Ribble Valley Borough Council
Council Offices, Church Walk
Clitheroe
BB7 2RA

Your ref: 3/2020/0840
Our ref: DC/20/4595
Date: 08-JAN-21

Location: 1 Ridding Lane Whalley BB7 9HW

Proposal: Change of position of rest shelter area to application 3/2018/1054. Addition of small shed. Addition of wooden structure 58ft x 30ft.

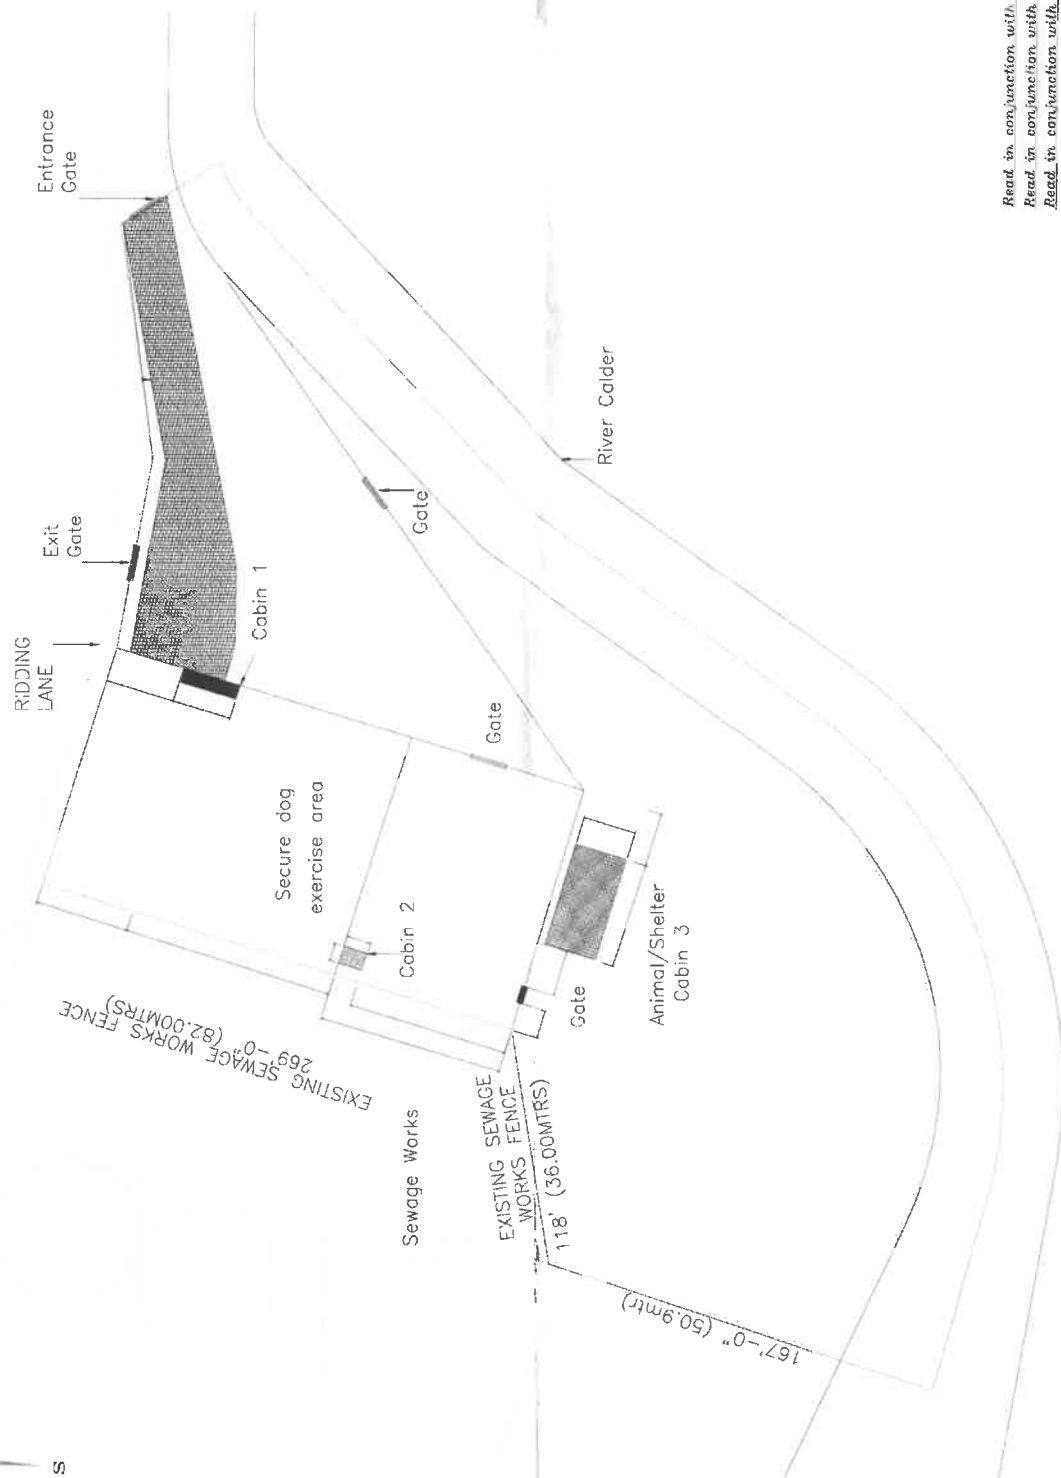
We have reviewed the proposals and note that there is significant infrastructure within the site boundary including a large combined sewer and underground tank. The submitted layout plan indicates that the proposed structures may lie on top of/ in close proximity to these assets and therefore until the exact location of our assets is confirmed and the impact assessed, United Utilities must **OBJECT to this proposal.**

A public sewer crosses this site and we may not permit building over it. We will require an access strip width of six metres, three metres either side of the centre line of the sewer which is in accordance with the minimum distances specified in the current issue of Part H of the Building Regulations, for maintenance or replacement. Therefore a modification of the site layout, or a diversion of the affected public sewer may be necessary. Due to the size of the sewer, a diversion at this location is unlikely to be acceptable. Wastewater Developer Services should be contacted to confirm. All costs associated with sewer diversions must be borne by the applicant.

To ensure the applicant does not incur any further delay or expense, we advise them to contact Developer Engineer, **Rob Brenton** by email at Wastewaterdeveloperservices@uuplc.co.uk to discuss their proposals and the location of our assets and to agree an acceptable solution.
